Subject: Land West of Pagham Road Pagham - P/155/21/RES

Planning Application Reference: P/155/21/RES

Proposal: Approval of reserved matters (layout, scale, appearance and landscaping) following outline consent P/140/16/OUT for the 'local centre' parcel which comprises of retail, community and commercial uses, 20 No residential apartments and a 70 bed care home.

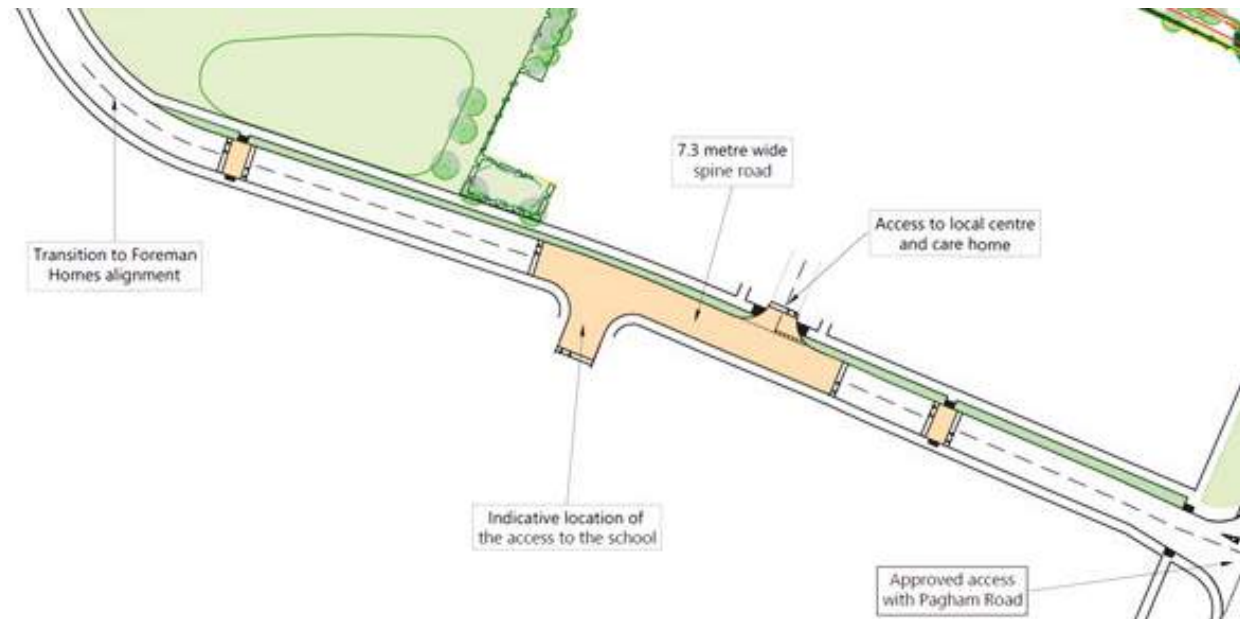
I note from the plan entitled 'the proposed site layout ref: 10165 PL01 REVC' (dated 29/10/2021) [produced by Robert Limbrick Ltd.] that no electric vehicle charging points have been included for the proposed care home parking spaces. I would view this as a new non-residential building (although it is a residential building, residents are not expected to own private vehicles, the parking provision is therefore for visitors and staff). As such the applicant is required to provide an electric vehicle charging point for every 1 in 5 parking spaces.
